Environmental Health Consultation Response

To	Aishwarya Reddy
Date	20-12-2024
Planning Ref	P/123/24/HH
Site Description	109 West Front Road Pagham Bognor Regis West Sussex PO21 4TB
Date of Application	2024-12-06 00:00:00
Category	Planning Permission For Works Or Extension To A Dwelling
Recommendation	No Objection No Objection – with conditions Objection Holding Objection

Planning Response P-123-24-HH - 109 West Front Road, Pagham, Bognor Regis, West Sussex, PO21 4TB

Proposed Elevations

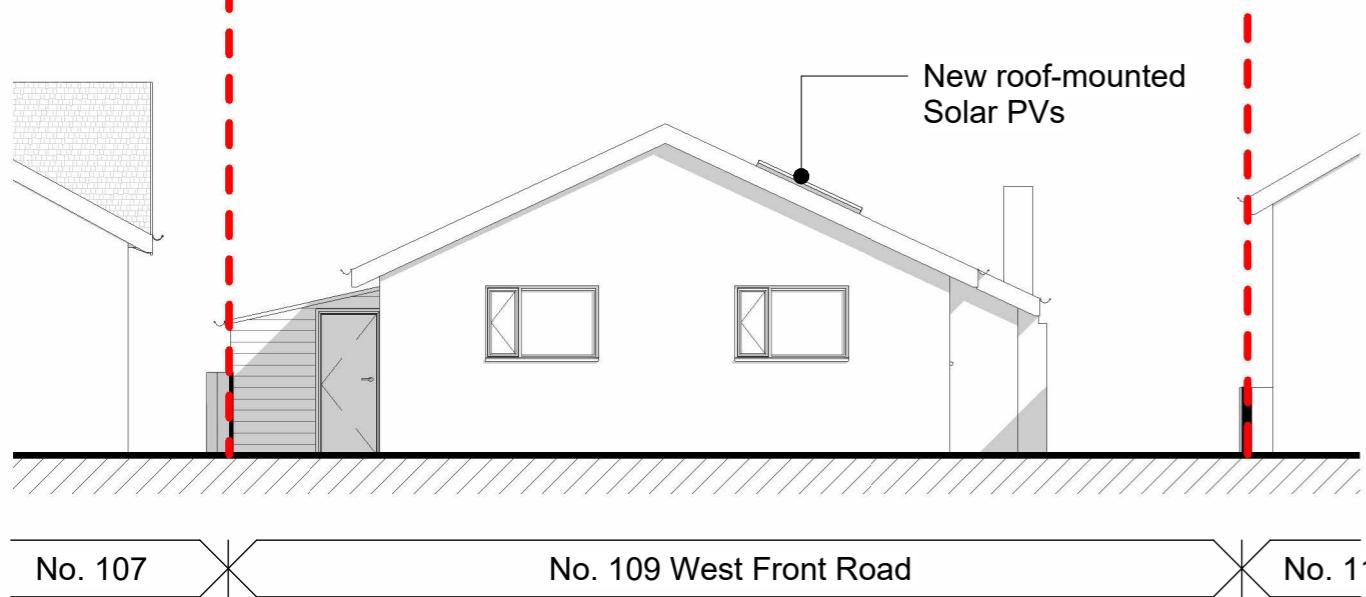
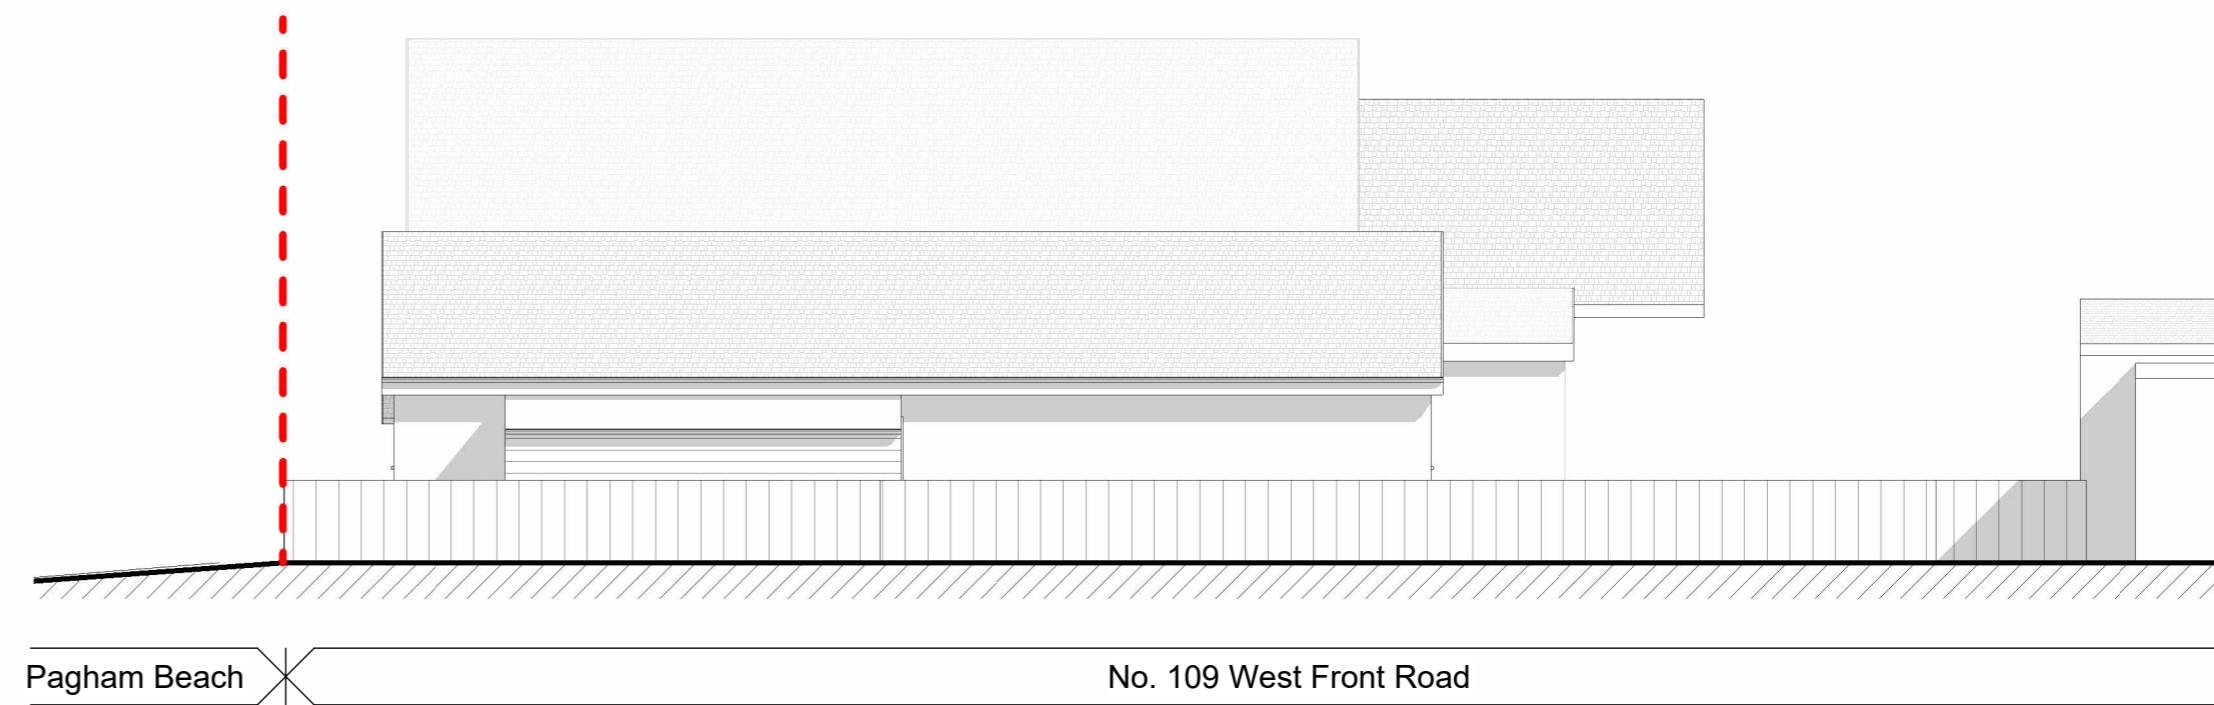
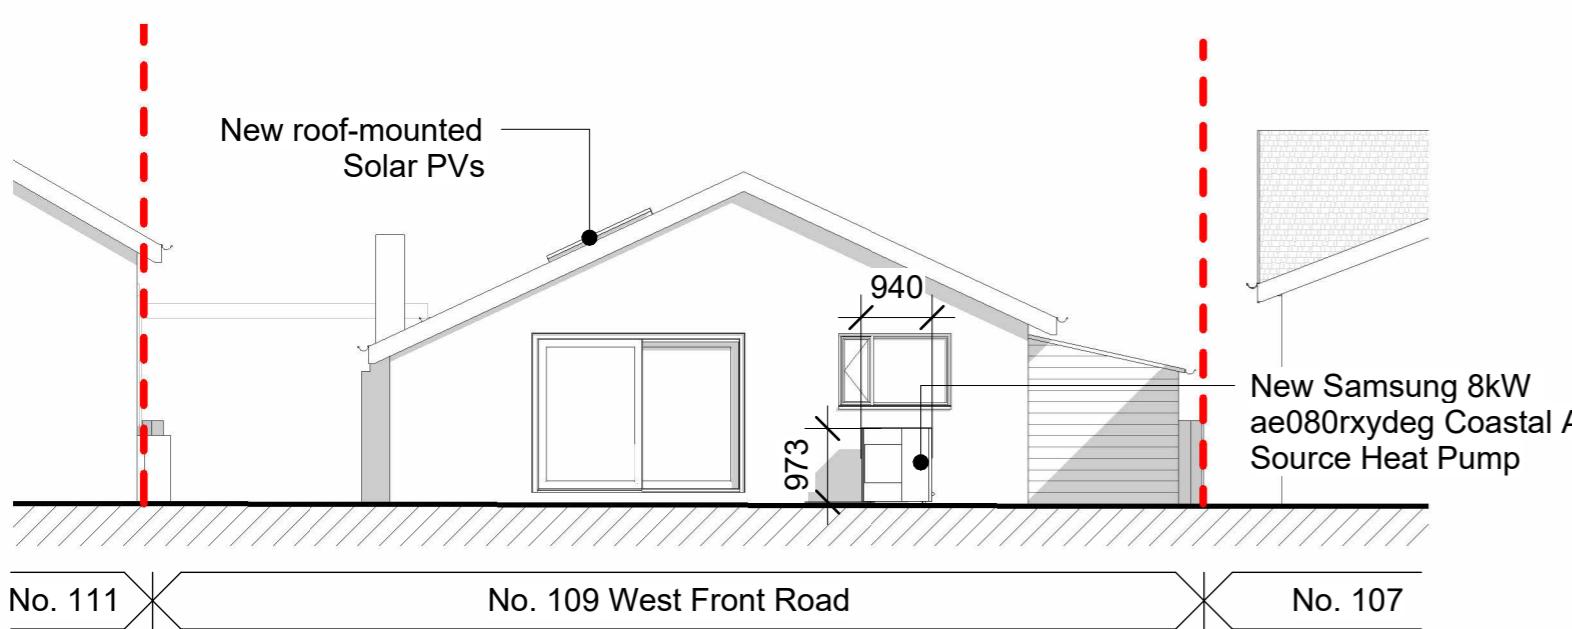
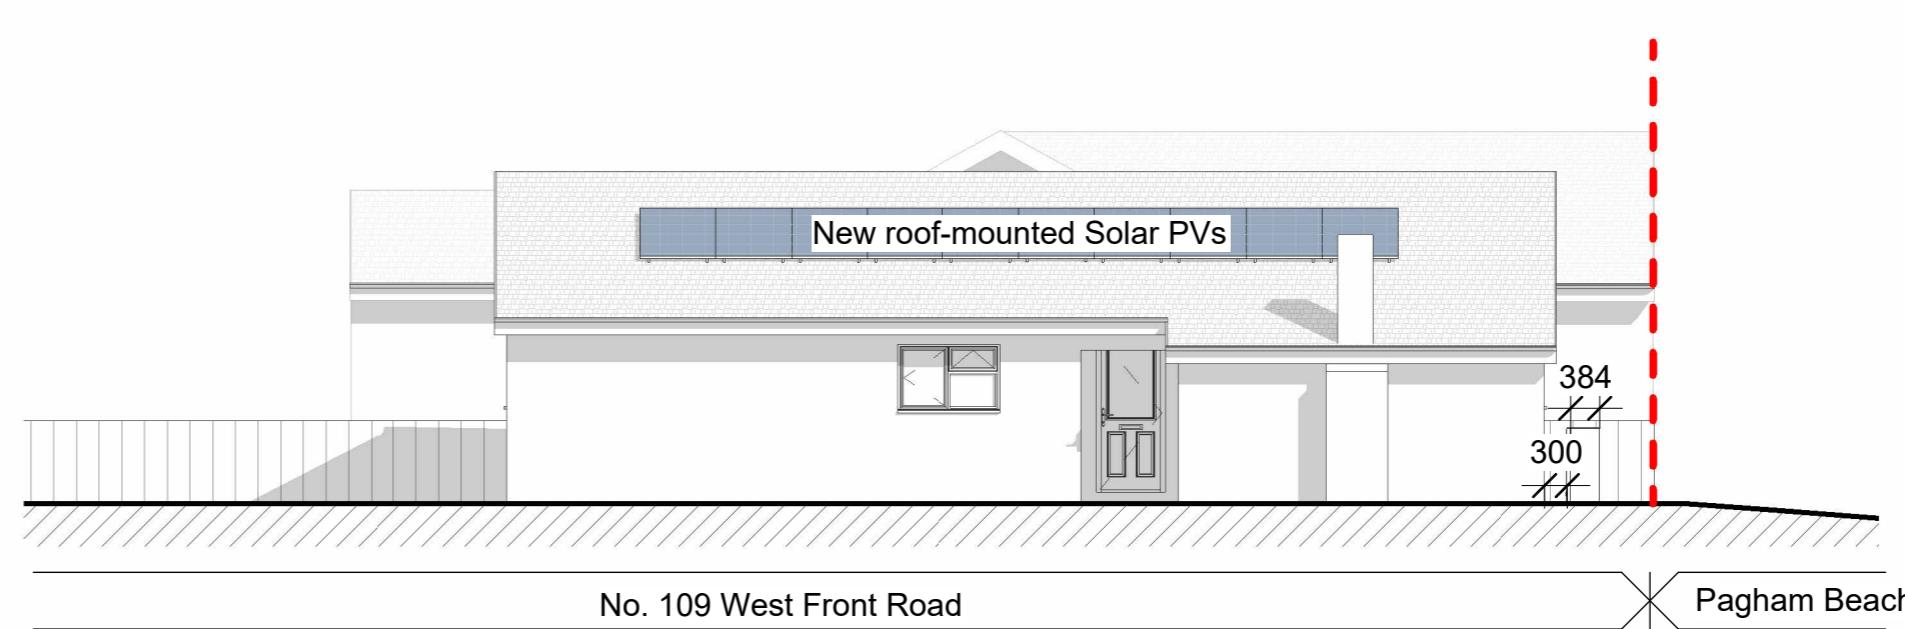
I have reviewed the above application, and I have concern bout the noise impact from the proposed air source heat pump depending on the unit these can be noisy and the 24 hour, on and off, use can be detrimental to the amenity of the nearby properties.

Before I can asses the impact from the proposed unit, we need to see evidence that the noise impact has been assessed in line with the existing background noise level.
